Application No: CM/17/21/PL
Site Address: Land at Wren Cottage Horsemere Green Lane Climping BN17 5QZ
Description of works: Development of 2 No. 2-bed & 2 No. 3-bed detached dwellings & associated works (resubmission following CM/53/20/PL). This site is in CIL Zone 3 & is CIL Liable as new dwellings.

Thank you for your internet representation made on 5th August 2021 which has been recorded as an objection with the comments as follows:

PLOT 1 ELEVATIONS
SCALE 1:100 @ a3

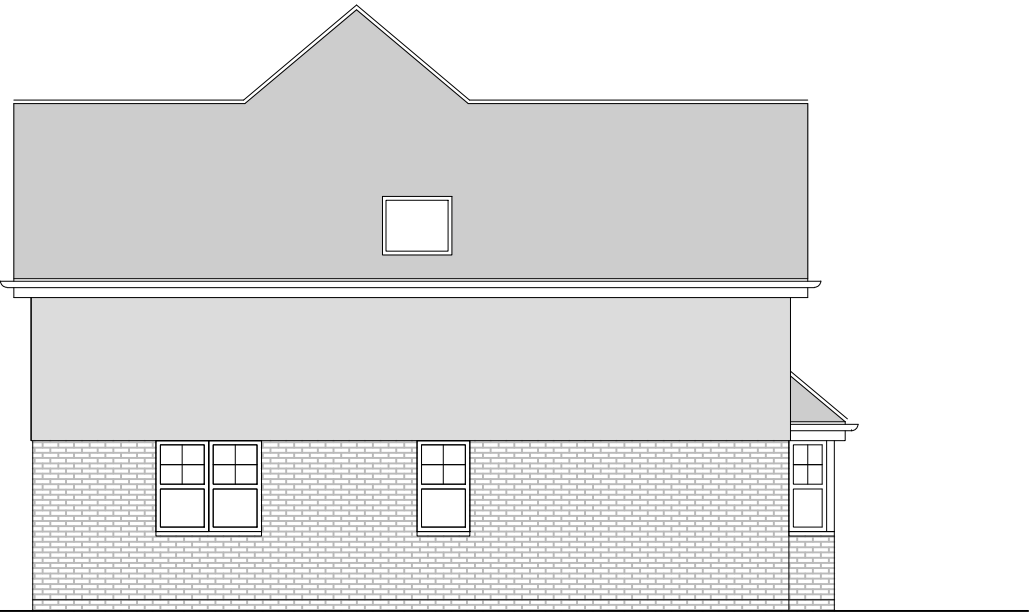
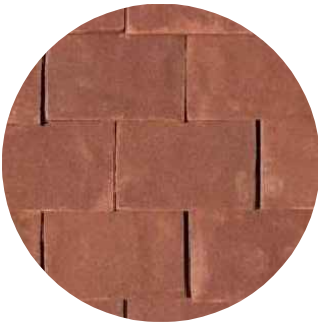
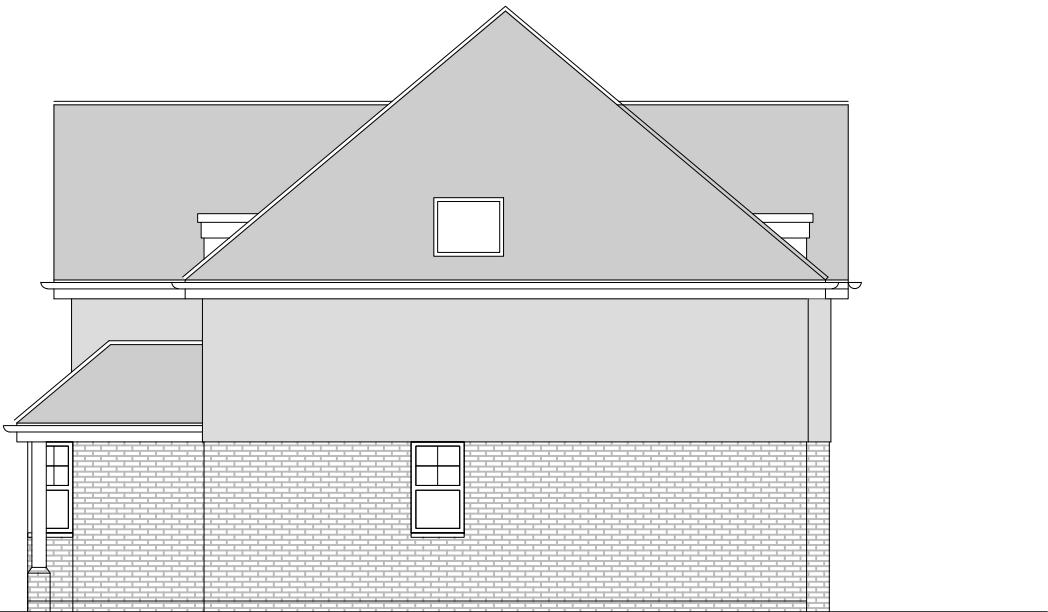
On top of this you are expecting me to be happy with the proposal of 4 new dwellings on the Wren Cottage land. Plot one which is directly opposite my bungalow will be a large 3 bedroom house with 2 large bedroom windows directly overlooking my back garden, 2 bedrooms and kitchen.

The resubmitted plans for plot 1 have not changed. Plot 2 to 4 are now 1 and a half storey with frosted windows facing west. Why has plot 1 not changed in line with the others. Plot 1 and 3 are 22m rear to rear

with 4 and 6 Wooldridge Walk so the alterations to plot 1's design should be in accordance with plot 3. All I want is to be treated equally.
